Consultee Comments for Application 2025/92242

Application number: 2025/92242

Location: Land off Hermitage Park, Lepton, Huddersfield, HD8 0JU

Proposal: Reserved matters application (including consideration of appearance, scale and landscaping) for the erection of 80 dwellings, pursuant to Section 73 approval 2025/90105 pursuant to previous outline permission 2022/91735, and the discharge of conditions 6, 7, 8, and 9

# 400 / GREYFORD (PLOT 12) PLANS & ELEVATIONS

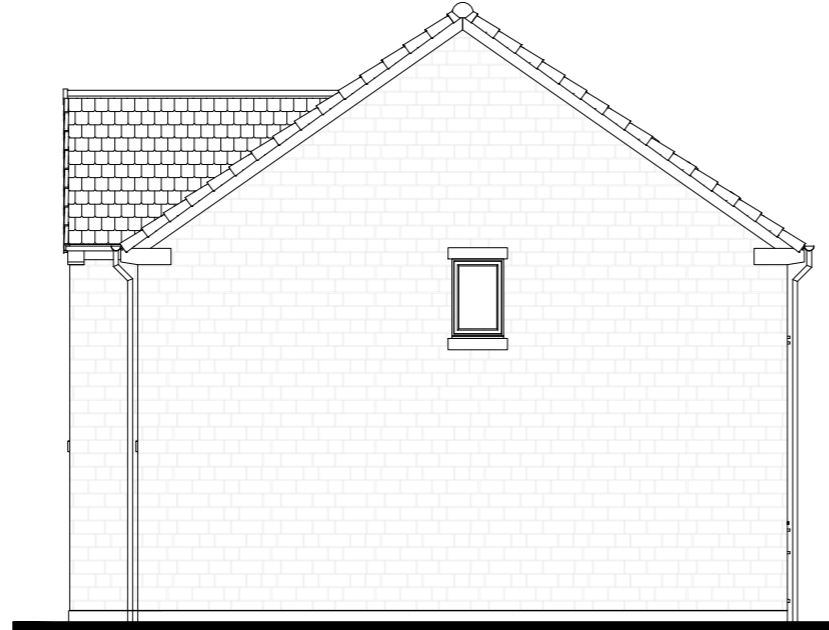
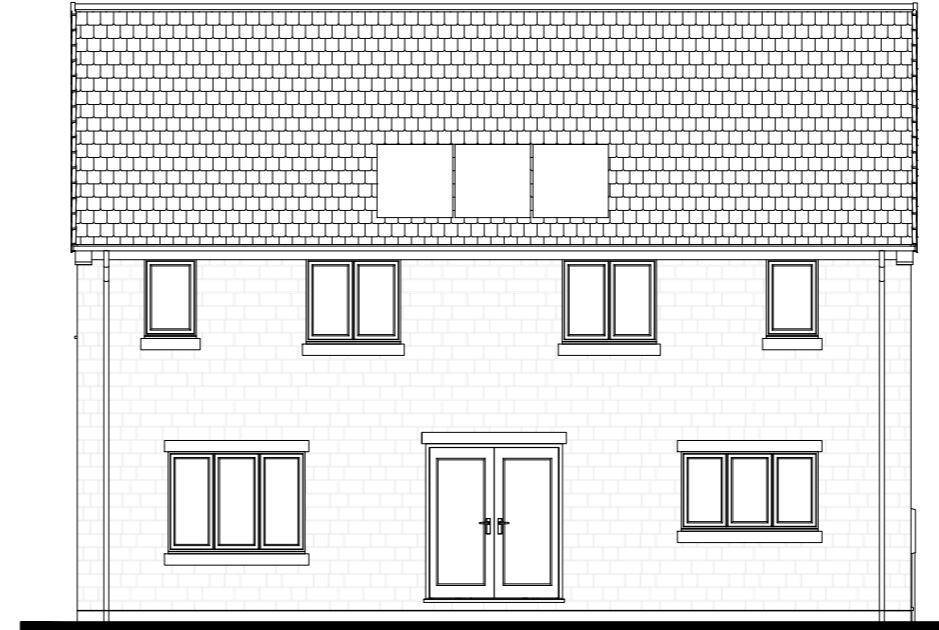
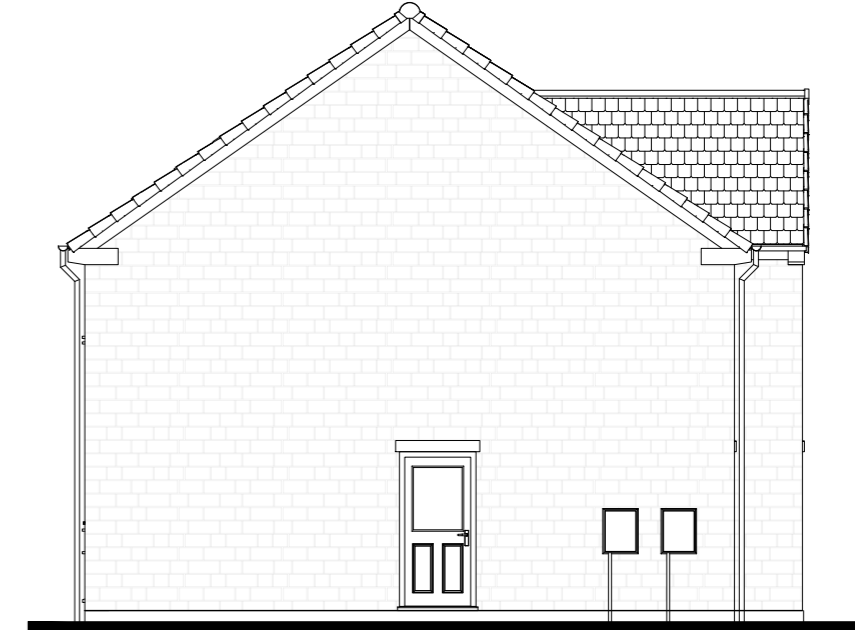
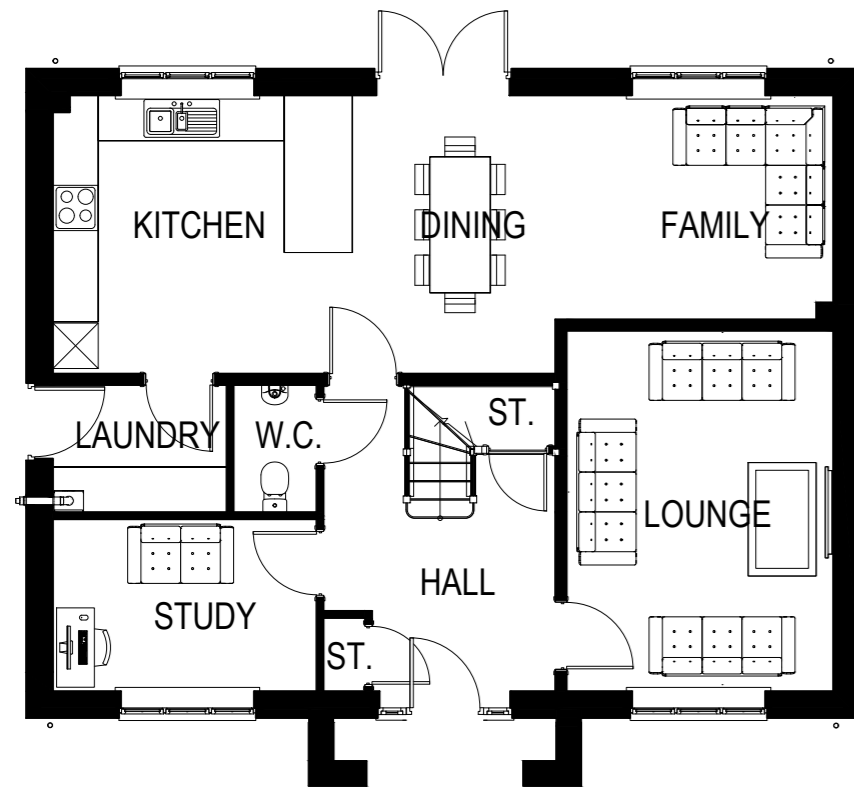
Greyford's main entrance features hiding spaces on each side of the doorset. Can this be altered? Otherwise, it will require to be mitigated with appropriate lighting and CCTV (if applicable).
